CITY OF ALBUQUERQUE

April 25, 2022

Re: **ot 2 A o Inte tate In t a T act /Lot 28-A of Interstate Industrial Tract**
E on St. NE /4000 Ellison St. NE
T a c C c at on a o t
Architect's Stamp 02-24-22 (D17-D074)

Based upon the information provided in your submittal received 04-20-22, the above referenced plan cannot be approved for Building Permit until the following comments are addressed:

1 SITE PLAN - TRAFFIC 1  
1" = 30'-0"

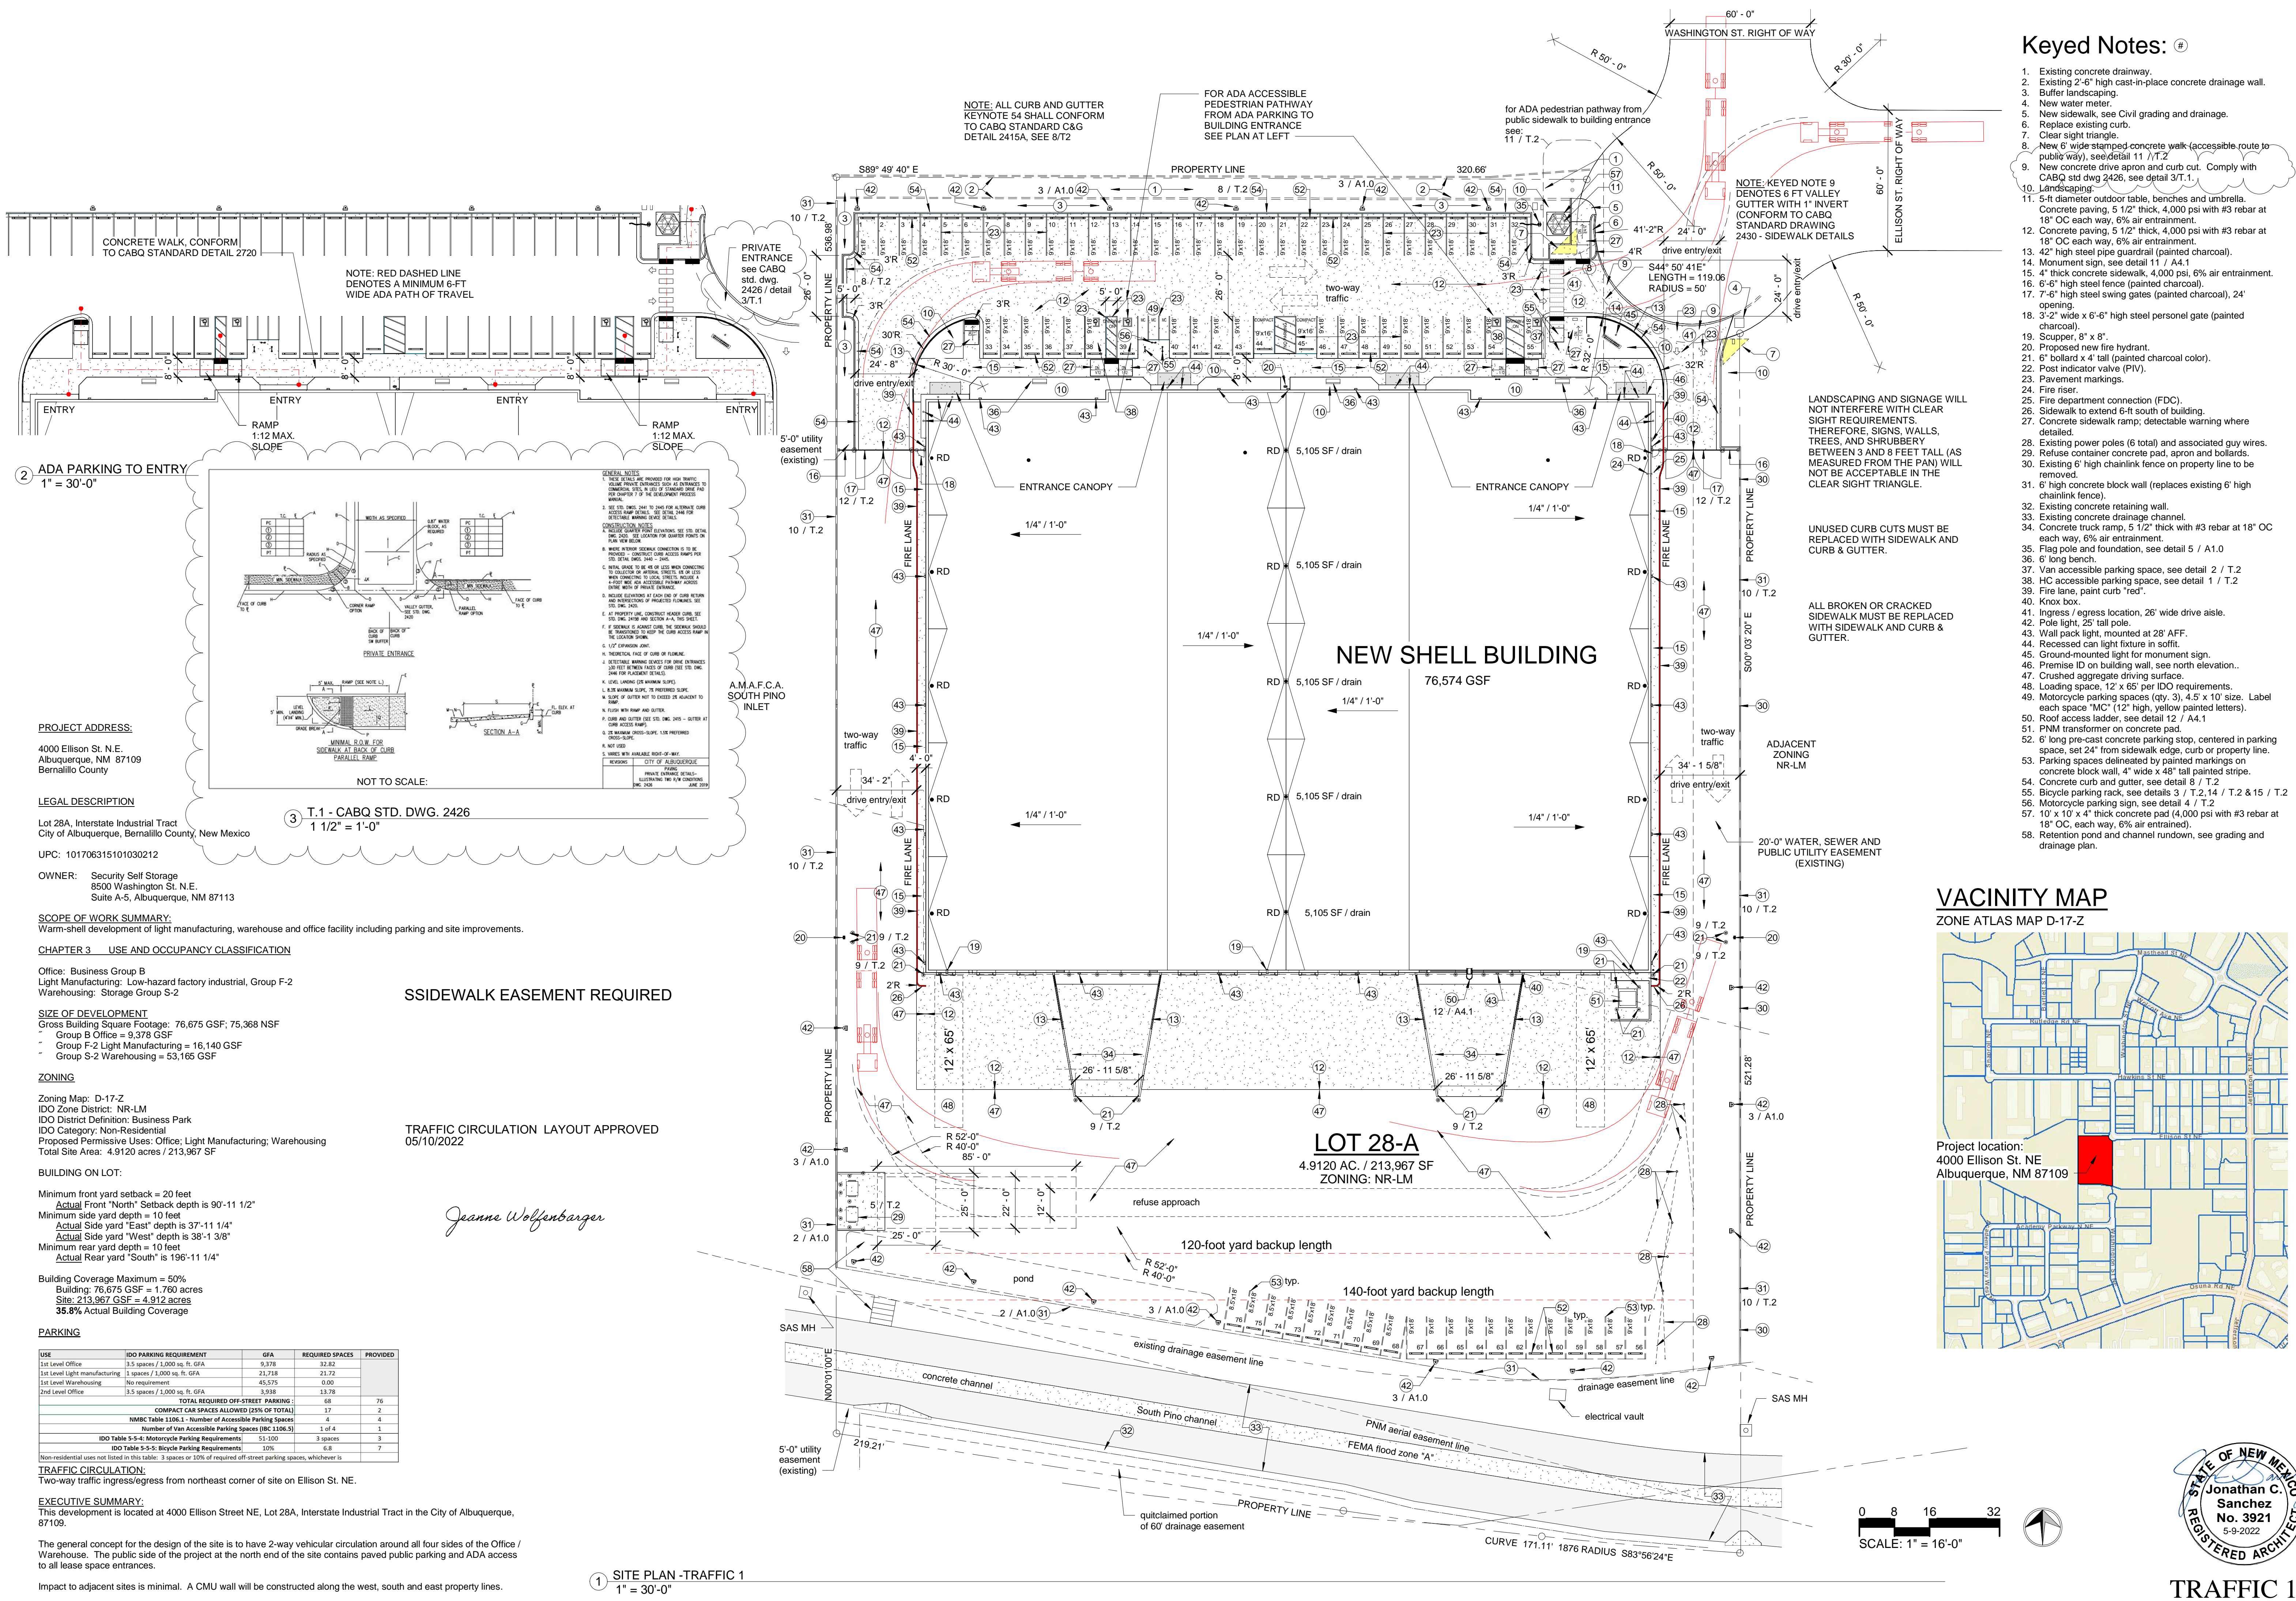
1. Please define the Property Line.
2. Provide both site accesses' width, radius, all details, and call out COA std dwg.
3. Maximum access width for arterial, collector, and local streets are as follows:

4. Provide the west and the northwest drive aisles' width.
5. Label the compact parking spaces by placing the words **COM ACT** on the pavement of each space.
6. The minimum drive aisle dimensions are shown below

7. List radii for all curves shown; for passenger vehicles. Radius for delivery trucks, fire trucks, etc. is 25 ft. or larger.
8. A 5 ft. keyway is required for dead-end parking aisles.

9. Per the IDO, a 6 ft. wide ADA accessible pedestrian pathway is required from the public sidewalk to the building entrances. Please clearly show this pathway and provide details.

10. Per DPM, a 6 ft. wide ADA accessible pedestrian pathway is required from the ADA parking stall access aisles to the building entrances. Please clearly show this pathway and provide details.

11. ADA accessible pedestrian pathway should not be placed behind parking space or adjacent to a vehicular way. Vehicle and pedestrian/wheel chair conflicts should be avoided as much as possible.

12. Refuse vehicle maneuvering shall be contained on-site. The refuse vehicle shall not back into the public right of way.; provide a copy of refuse approval.
